October 8<sup>th</sup>, 2013

**RE: ZONING BY-LAW AMENDMENT  
2940 & 2946 BASELINE ROAD (FILE #D02-02-12-0077)  
PLANNING RATIONALE ADDENDUM AND RESPONSE TO TECHNICAL COMMENTS**

Proposition -1.2-
Elevations - Building A
Scale: 1:250
2012.06.26

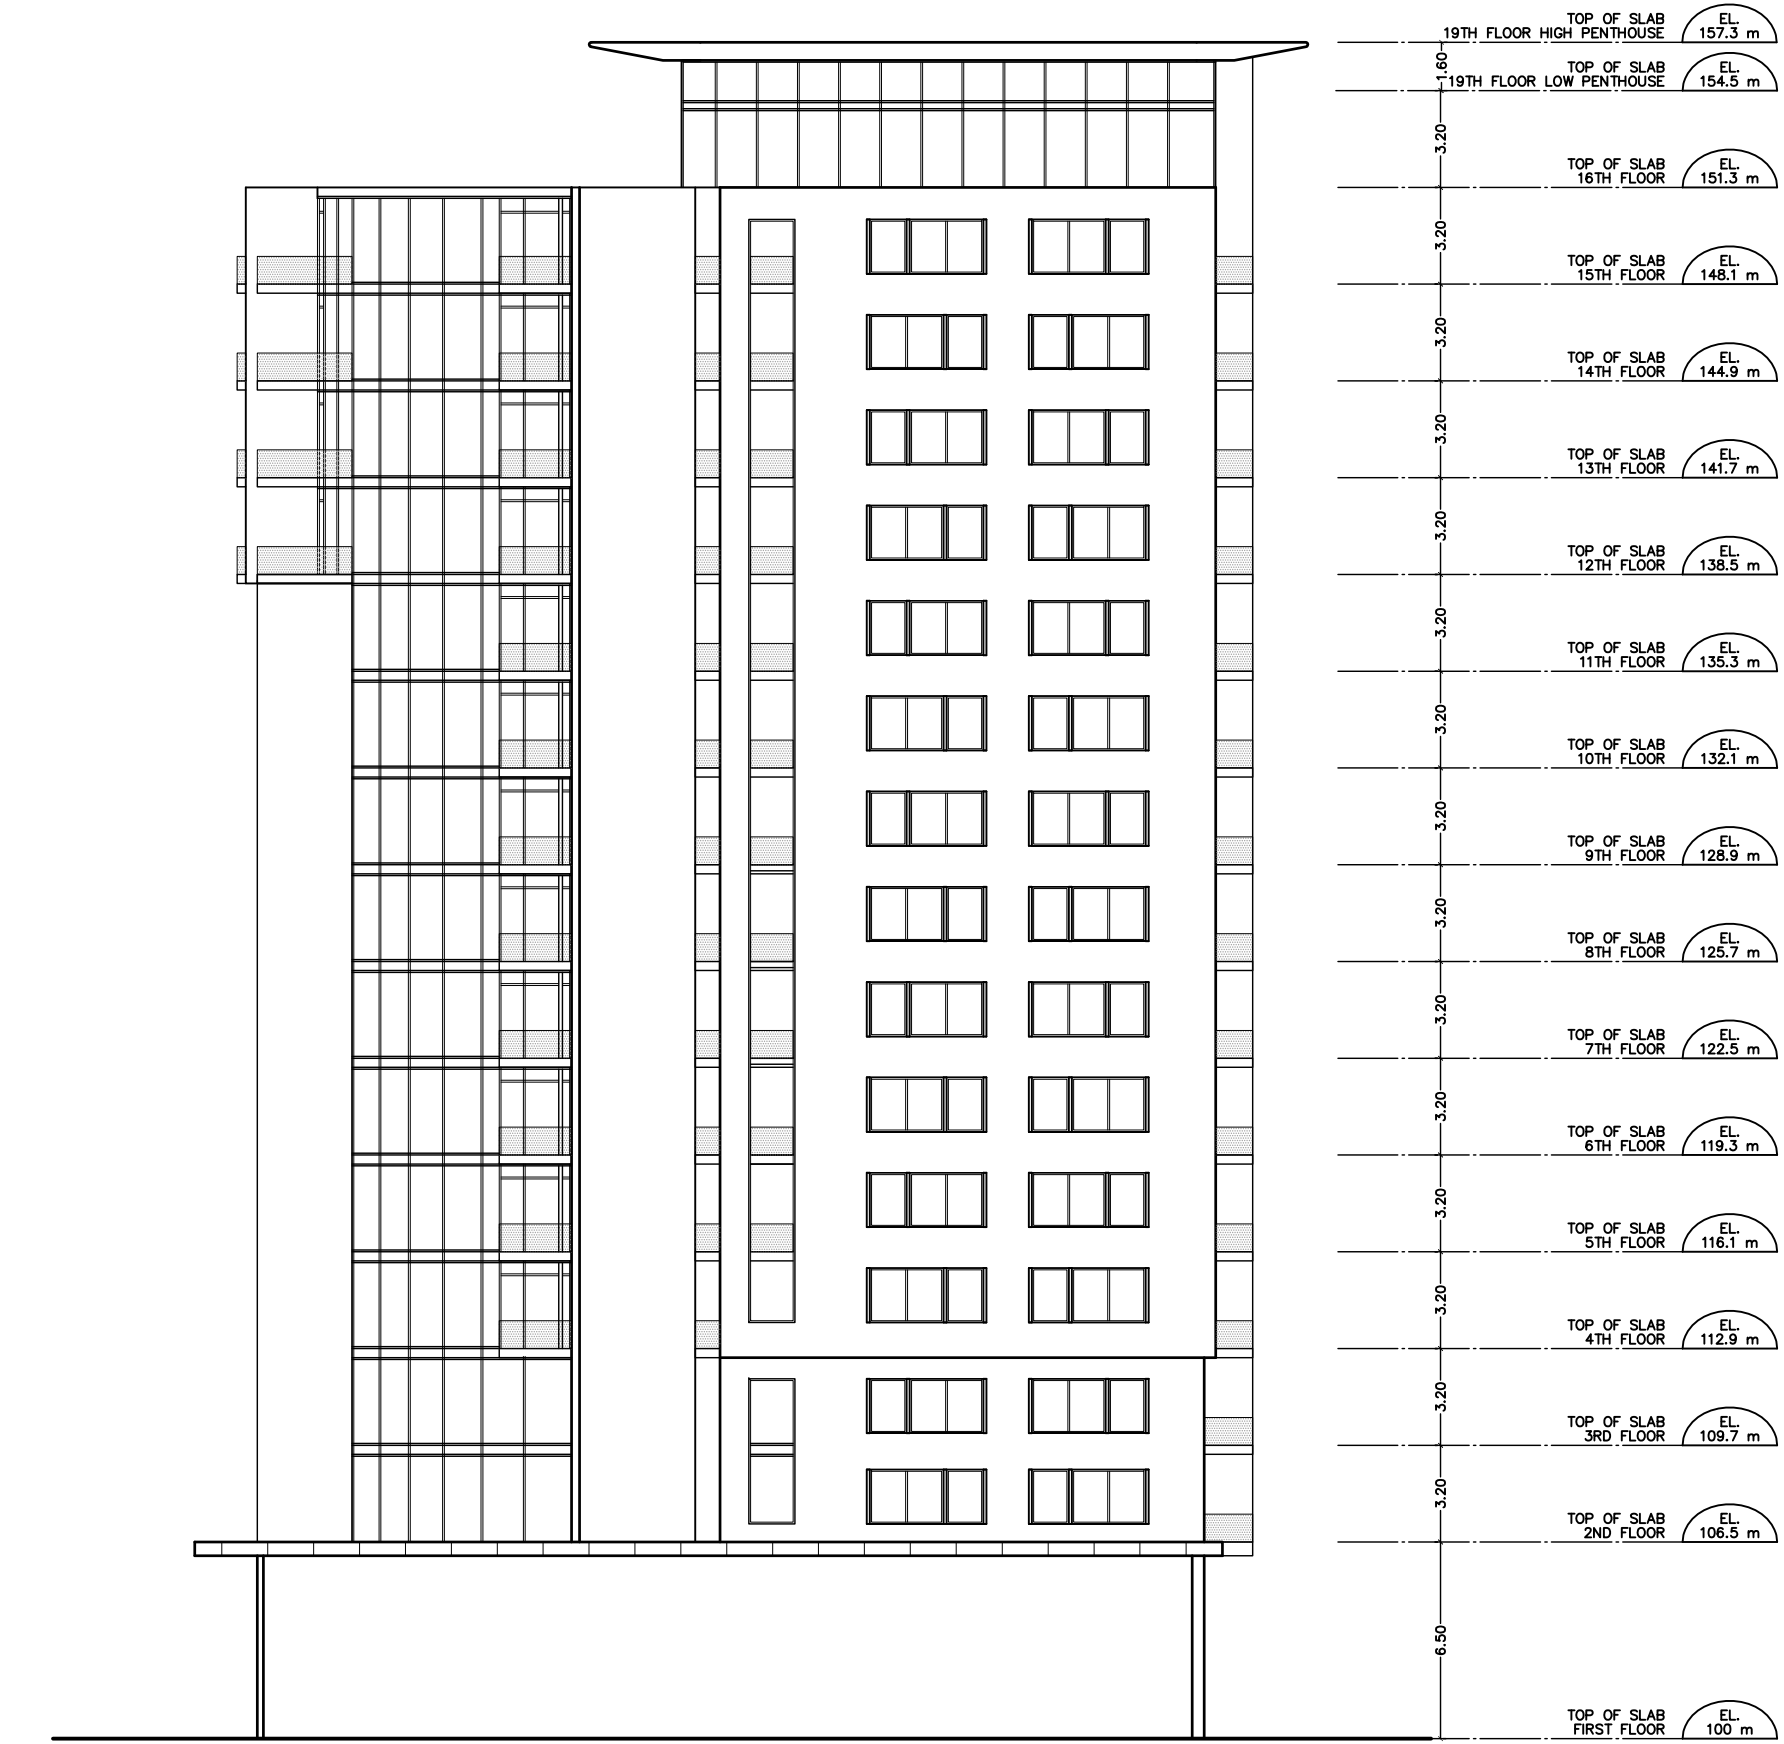
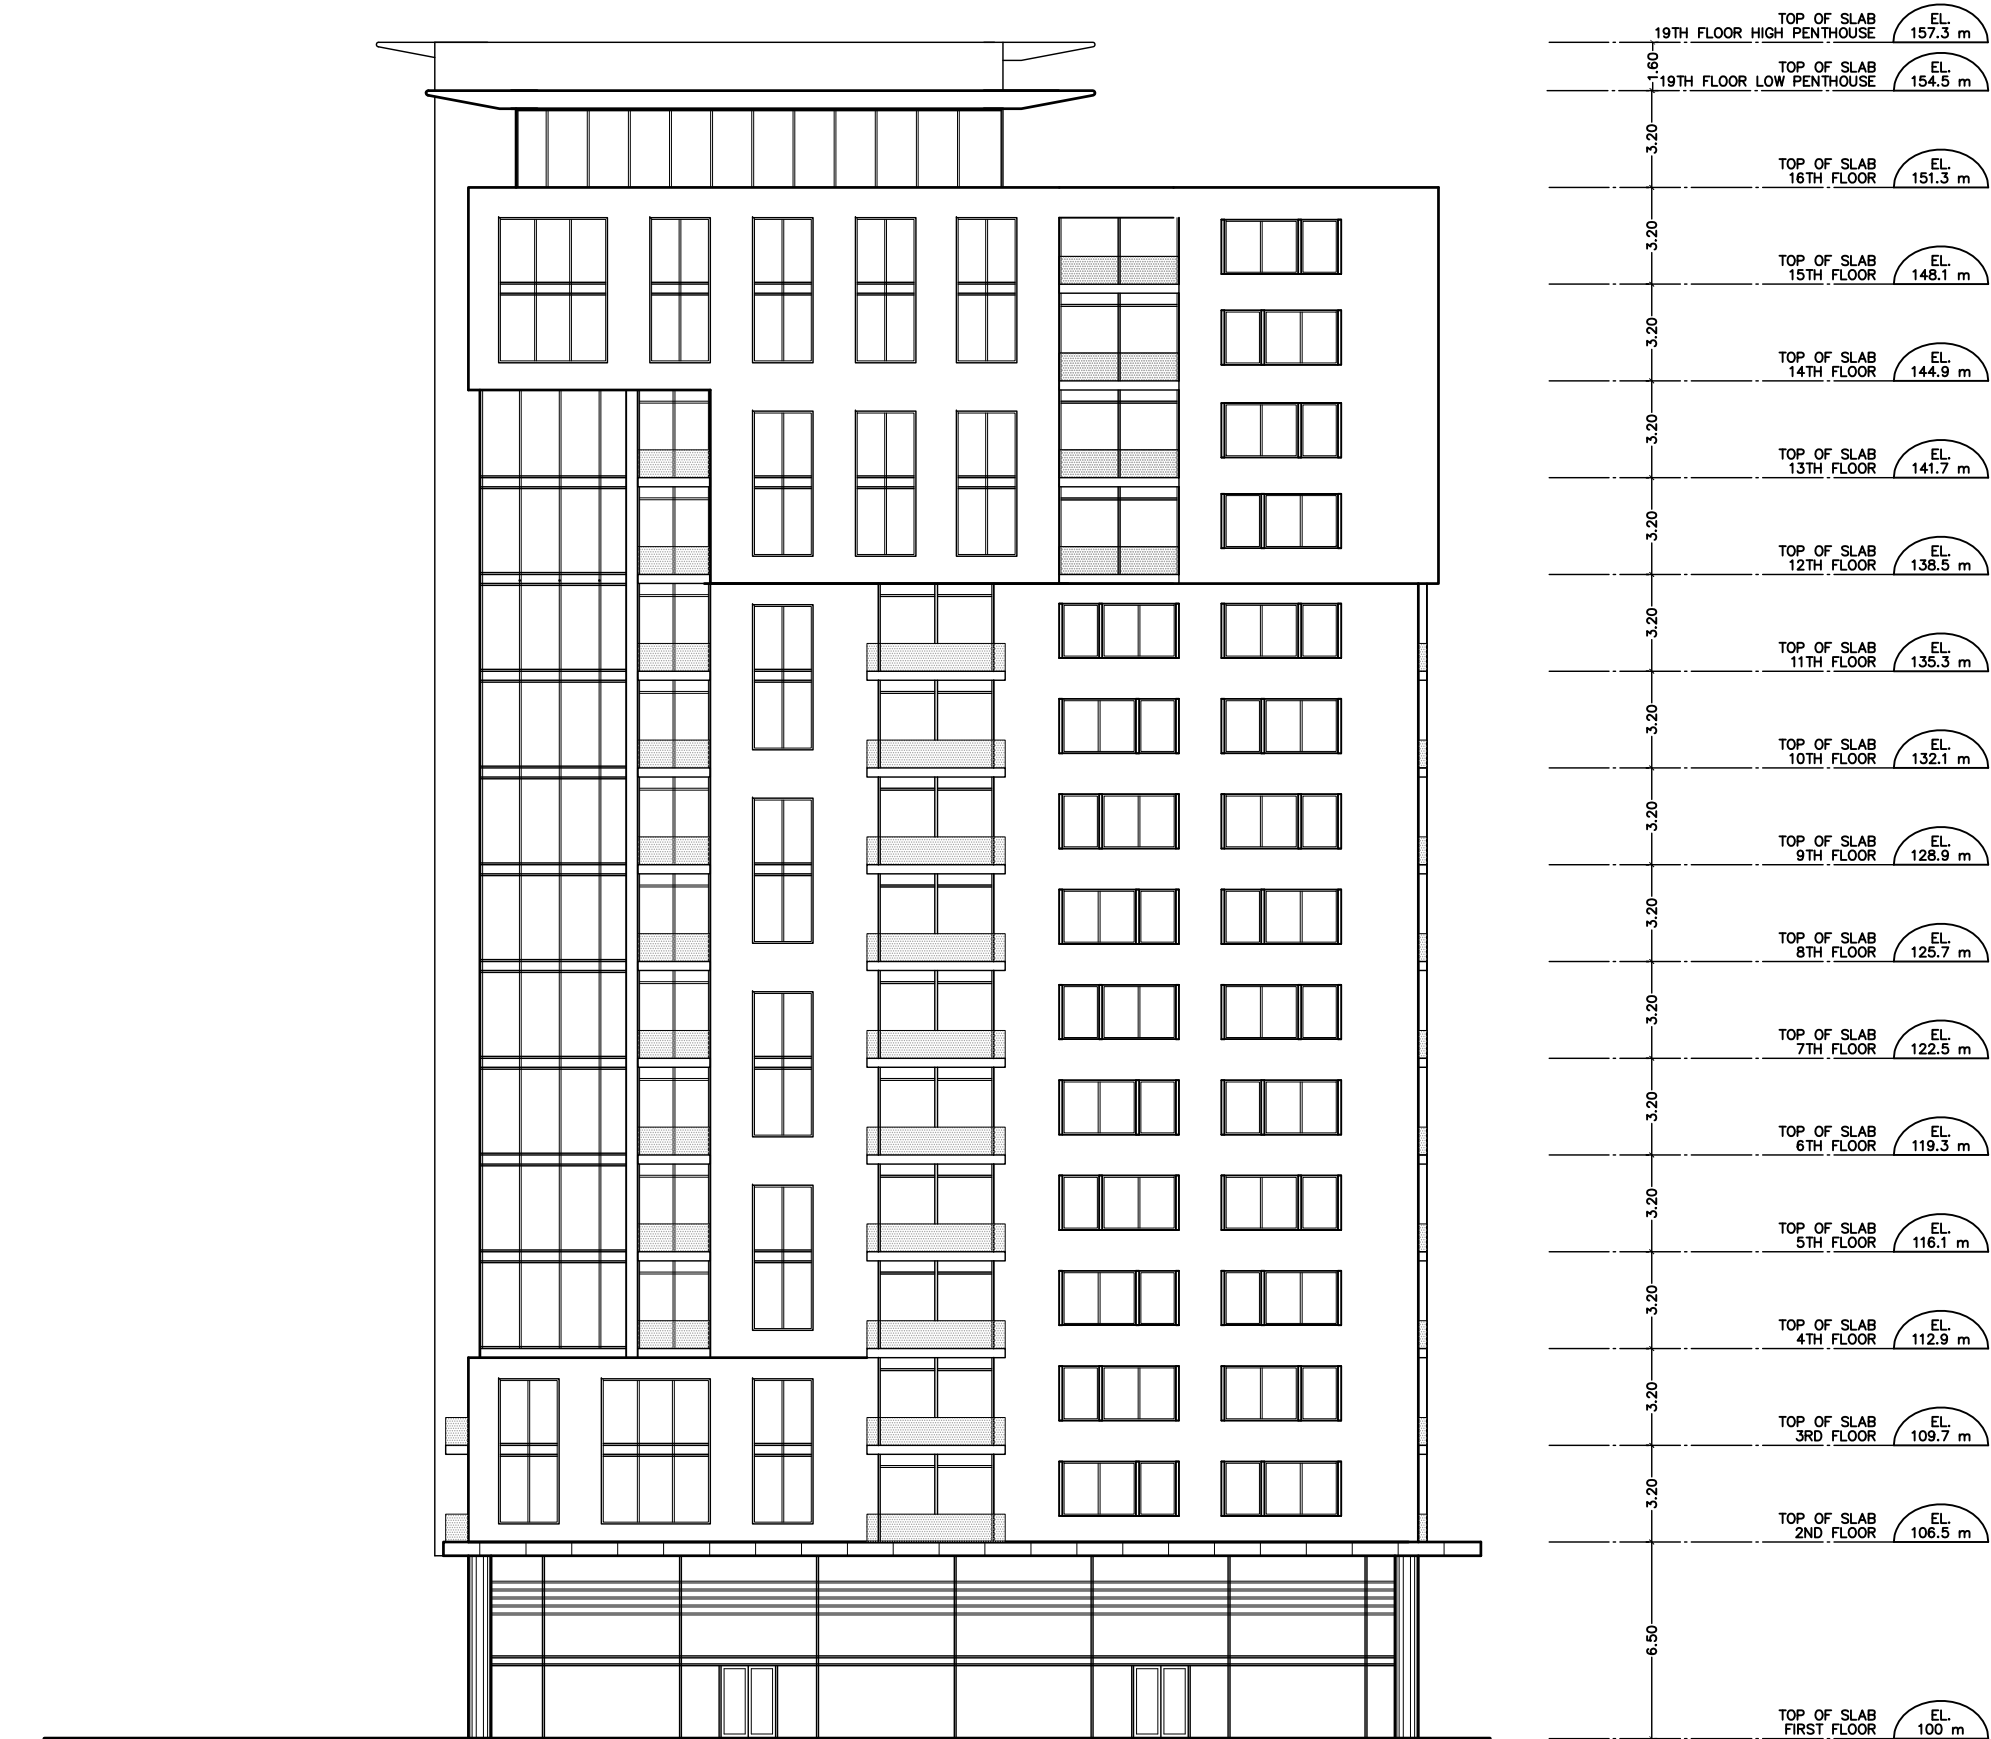
- The effect on the skyline of the design of the top of the building is not addressed.

- Architectural design (e.g. the use of angular planes, cornice lines) – There is a lack of information regarding the design of the bases or podiums.

- The top of the building is designed with a sloped roof to add visual interest, the eastern halves of which are grated to ensure views and allow sunlight to pass through. Generous glazing at the upper levels of the buildings will reduce visual impacts, and trees on the amenity spaces will also be visible from a distance. The roofs will be visible from all directions.

- NEUF, the project architect, will provide colour renderings and elevations, to better understand the proposed architecture. In the interim, please refer to Perspectives drawings in the submission package.
